**From:** Andrew Wood <Andrew.Wood@arun.gov.uk>  
**Sent:** 03 February 2020 10:40  
**To:** Planning.Responses <Planning.Responses@arun.gov.uk>  
**Subject:** FW: Merry England, Angmering - OWC Application

**From:** Chris Slade [REDACTED]  
**Sent:** 28 January 2020 16:08  
**To:** Paul Cann <Paul.Cann@arun.gov.uk>  
**Cc:** Sarah Burrow <Sarah.Burrow@arun.gov.uk>; James Elsey [REDACTED] Andrew Wood <Andrew.Wood@arun.gov.uk>  
**Subject:** Merry England, Angmering - OWC Application

**RE: Land Drainage Works – Development at Merry England, Dappers Lane, Angmering**

Culverting of watercourse including provision of headwalls to facilitate vehicular access, and discharge to watercourse via new headwall, at Merry England, Dappers Lane, Angmering

CGS civils Consulting Civil Engineers			
CLIENT GD GROUP			
ARCHITECT CITYZEN			
JOB TITLE MERRY ENGLAND ANGMERING			
DRAWING TITLE CONSTRUCTION DETAILS SHEET 1 OF 2			
DRAWN LH	ENGINEER	CHECKED CS	APPROVED
DATE SEPT 2019		SCALE @ A1	1:20
JOB NO. C1249	STATUS P	DRAWING NO. 300	REV. P2

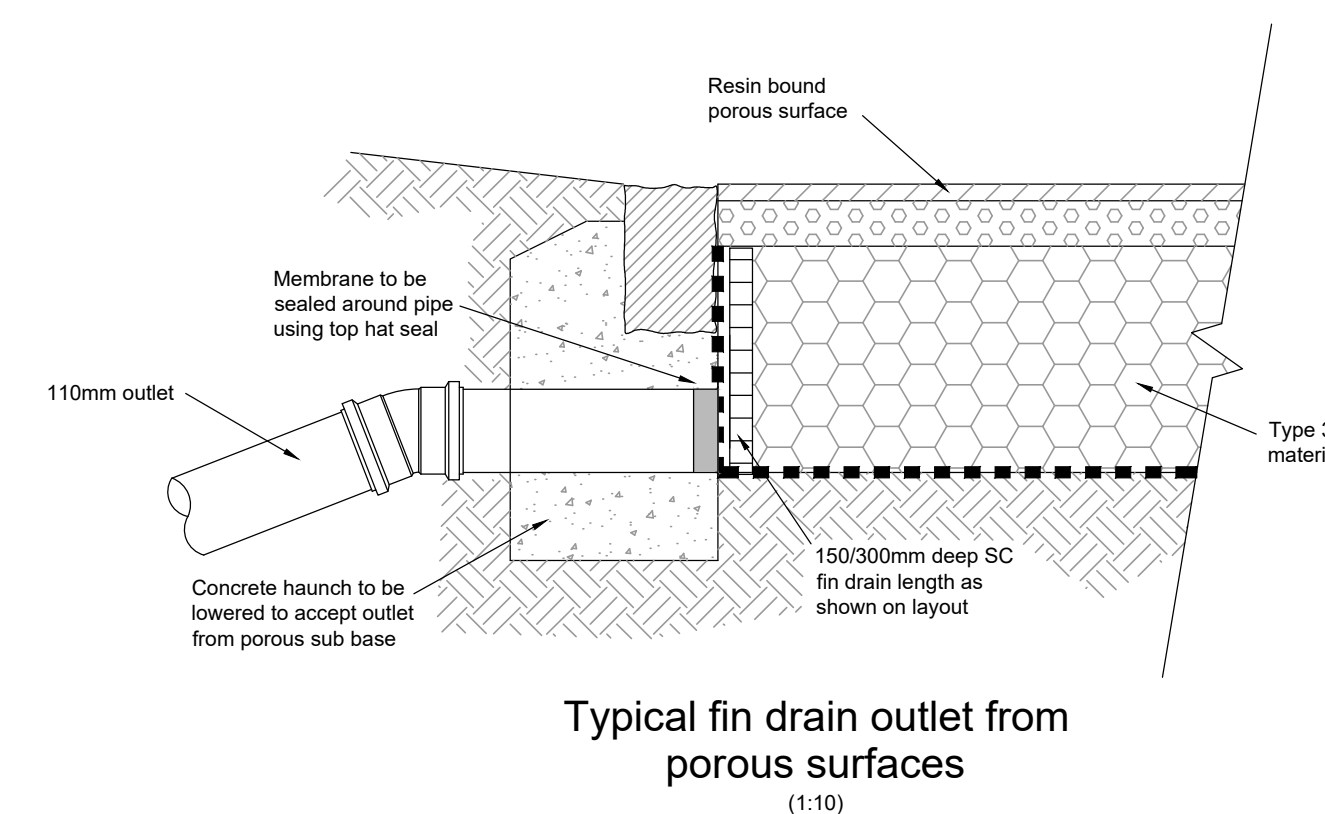
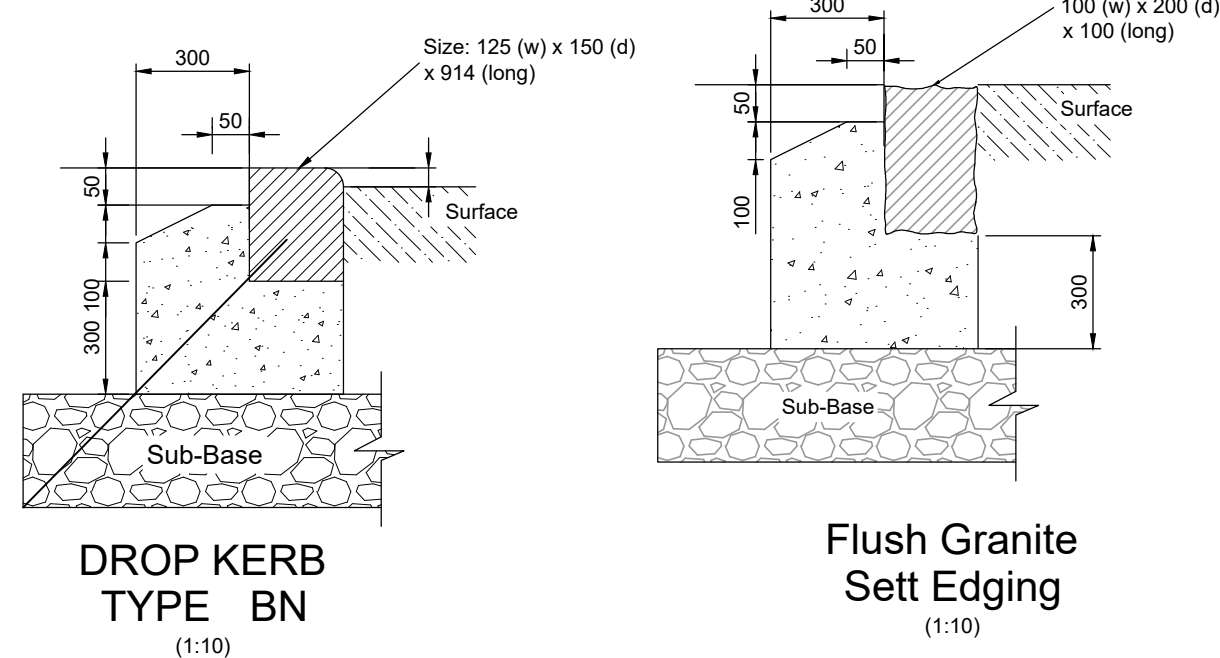
6. Noted.
7. Noted.
8. Noted.
9. Noted.
10. The numbered notes on the drawing I sent you, should also be included on your drawing -- Noted and added
11. Your drawings says 100mm freeboard as opposed to 70mm, and your long section indicates that you will be adjusting the ditch bed at this location. Please advise/make clear. Absolute min.100mm required -- Noted. This was an error in the email. The adjustment to 100mm took place after the response was drafted. It is 100mm as shown.

8. The pipes concrete bed and surround will require expansion joints on all joints. Provide detail.
9. Culvert gradient will need to be specified.
10. The brick headwalls for the culvert will require reinforced concrete aprons and also wingwalls (wingwalls can be concrete paving slabs – see attached detail). Specify class B engineering brickwork in english bond. Headwall widths to comply with enclosed detail.

11. Surface water outfall headwall – specify existing/proposed ditch bed levels at this location. We need to ensure the maximum possible freeboard between ditch bed and outlet pipe invert. The standard headwall detail needs to specifically refer to HW1. Width and wall thickness dimensions to be specified, and mesh reinforcement spec. Please note this construction detail appears on two separate drawings.

The detail you provided has been added to both the section through and the OWC drawing attached. Please find attached.

Surface water headwall has been added onto the section through drawing. A 70mm freeboard between ditch bed and outlet pipe has also be added onto the section-through. Due to the limitations we have in the network as well as the desire to not alter the ditch levels, this is the highest we could achieve.
